Our ref: DOC20/408216

Your ref: SSD-10388

Subject: EES comments on Environmental Impact Statement for Liverpool Hospital Multi-storey car park Project – SSD-10388

Subject: EES comments on Environmental Impact Statement for Liverpool Hospital Multi-storey car park– SSI-10388

A ELEVATION A THROUGH MULTISTOREY COURTYARD
1:200 @ A1

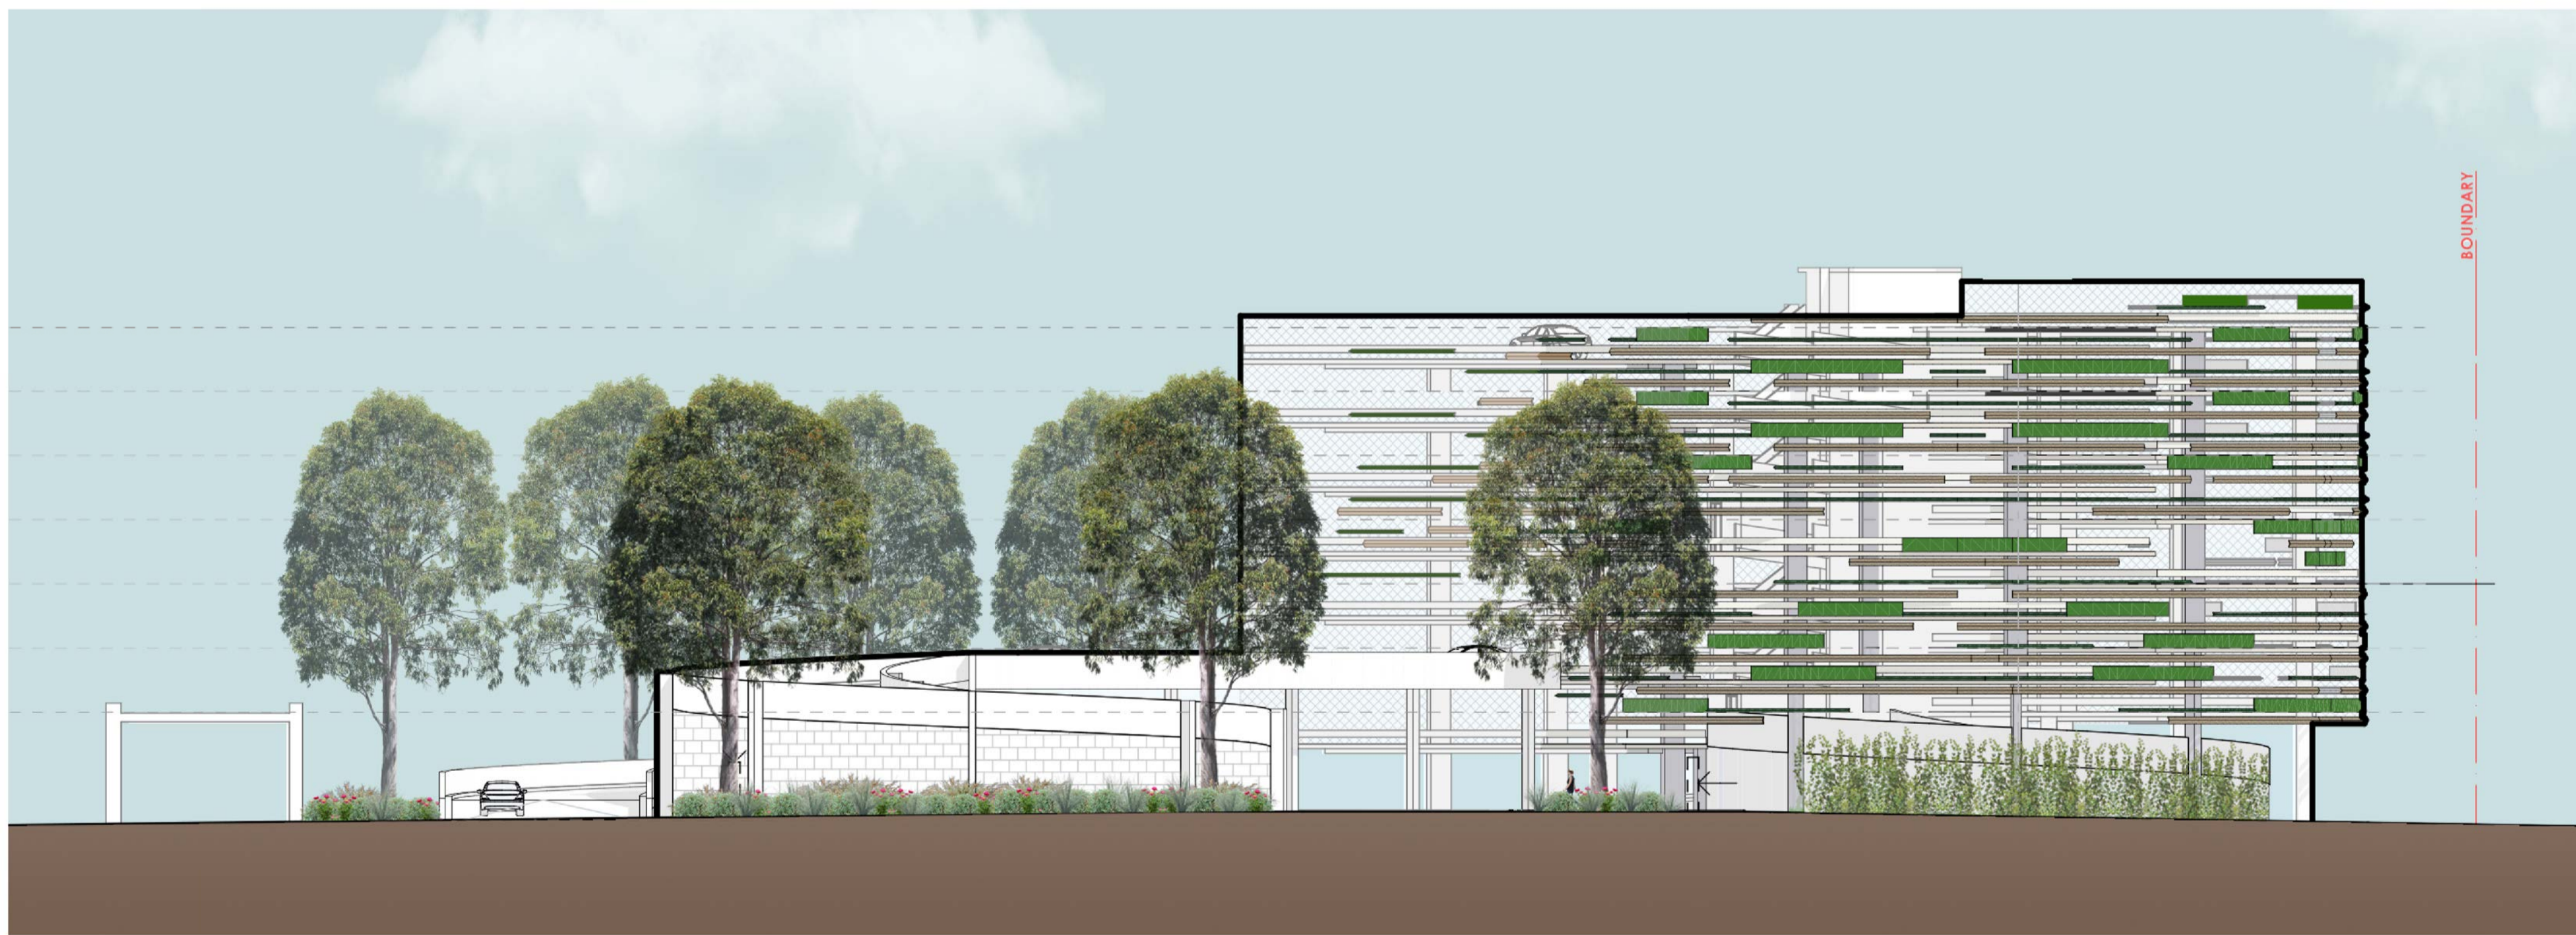
The LDR indicates artificial synthetic turf is proposed to be used on site where shading is an issue with the car park (page 9). It is recommended the RTS considers whether there are any other more natural alternatives rather than use synthetic turf. The Planning and Assessment Group (PAG) should consider potential issues associated with using synthetic turf as opposed to using natural non-invasive grass including:

- natural grass provides a cooler surface than artificial turf surfaces which get much hotter and absorb radiant heat (sunlight) and potentially add to the urban heat island effect by radiating the heat back into the air
- natural grass surfaces (as opposed to synthetic grass) provide some habitat value for certain native fauna.
